Application 3/2011/0971 Cobden Mill, Sabden

Site inspection 6 January 2012.

A Dowd
6 January 2012

client:	project:	drawing:
SP	Cobden Mill, Salsdon	Streetscene Elevations

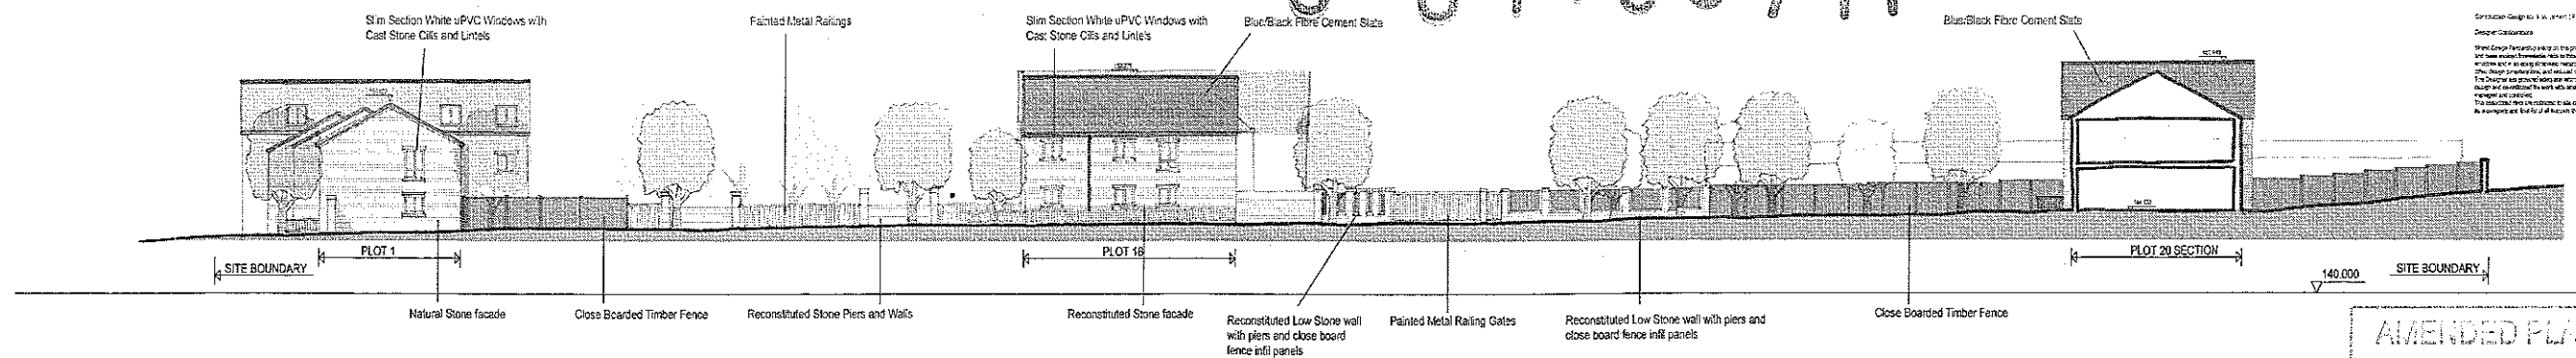
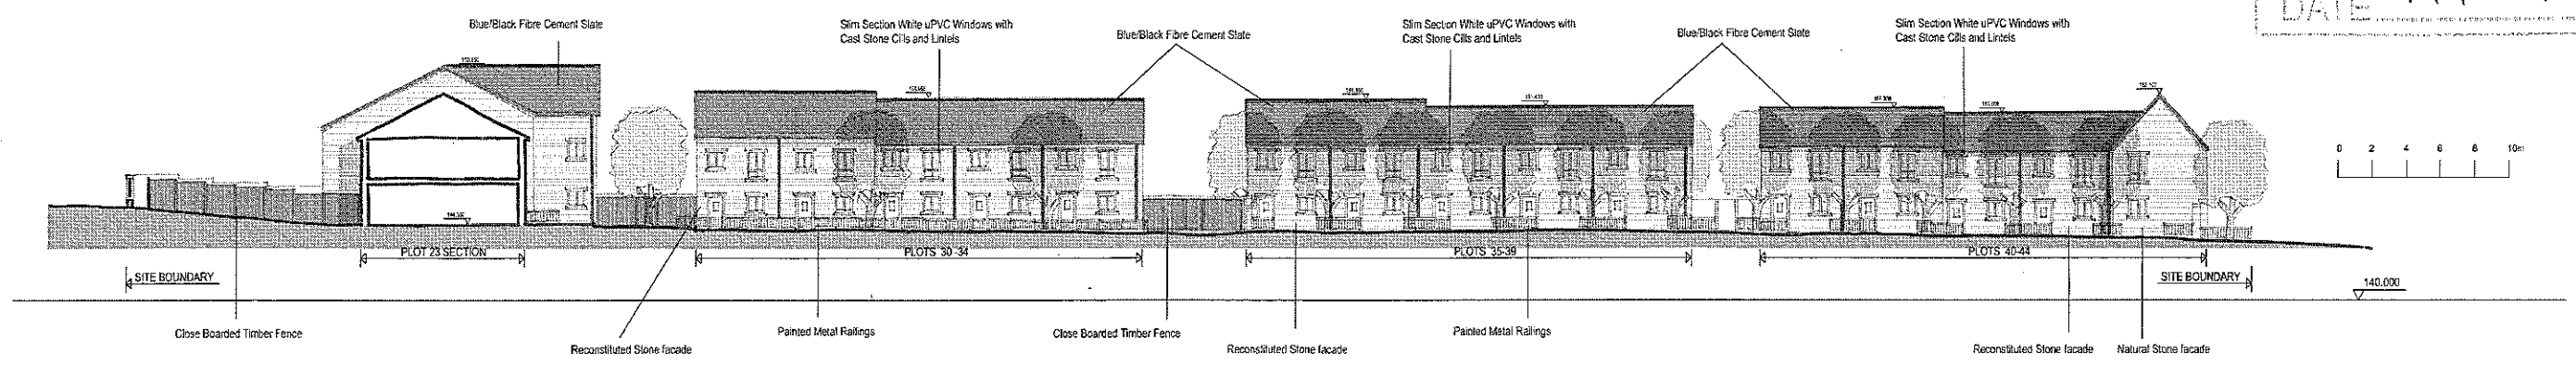
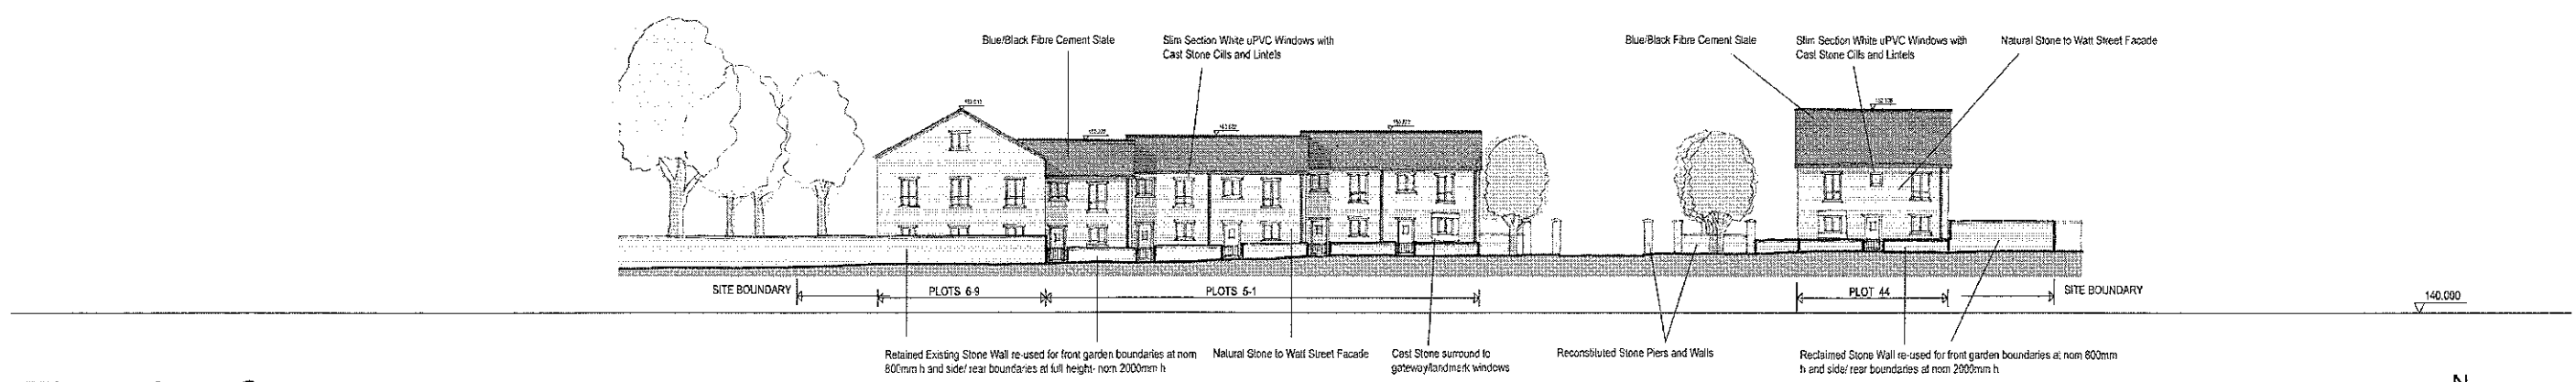
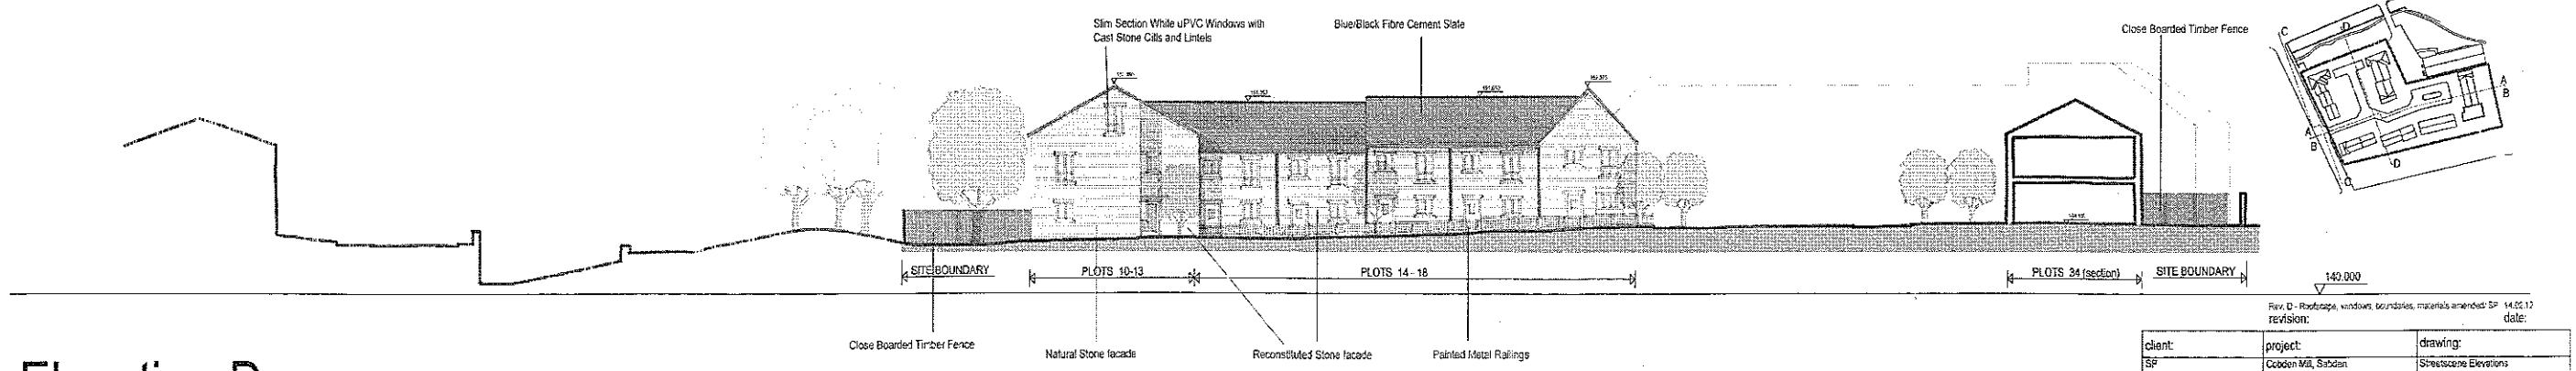
- (i) Unsympathetic fenestration – white uPVC windows/patio doors (see Sabden Conservation Area Appraisal [The Conservation Studio; adopted by the Borough Council following public consultation 3 April 2007] SWOT analysis Threats). The character of the conservation area would suggest vertically emphasised openings and a consistent treatment within terraces/blocks (there are a number of different window shapes even within the front elevations of one unit). The distinct and characteristic two-storey windows to the former Roman Catholic church and school at 1-7 Pendle Street East (noted in Appraisal ‘Key unlisted buildings – Buildings of Townscape Merit;’) appears to be a spurious and reoccurring theme incorporated (with ‘Juliet’ balconies) within the scheme;

- (ii) Flat roofs, hipped roofs and gables are a dominant theme but do not connect to the character or appearance of the conservation area;
- (iii) Roofscapes are further weakened by the absence of chimney stacks – Sabden’s valley bottom location and the impressive approaches from the hills to the north and south make this significant;

- (iv) Unsympathetic and non-traditional materials palette;
- (v) Removal of historic boundary walling and replacement with extensive close-boarded fencing. The Sabden Conservation Area Management Guidance (The Conservation Studio; subject to public consultation) notes *‘Traditionally most boundaries in the Sabden Conservation Area are defined by stone walls for new development in Sabden, it is important that local materials and detailing are used and new boundaries following the historic precedent of stone will help development to fit in to its context close-boarded fencing, with timber posts, may be an alternative to stone in certain locations away from the public viewpoint’*;

In my opinion, the proposed development would be conspicuous, incongruous and visually intrusive because of its design (fenestration, roofscape, use of gables, boundary treatments) and materials (modern and unsympathetic). This would be unduly harmful to the character, appearance and significance of the setting to Sabden Conservation Area and contrary to Policy ENV16 of the Ribble Valley Districtwide Local Plan.
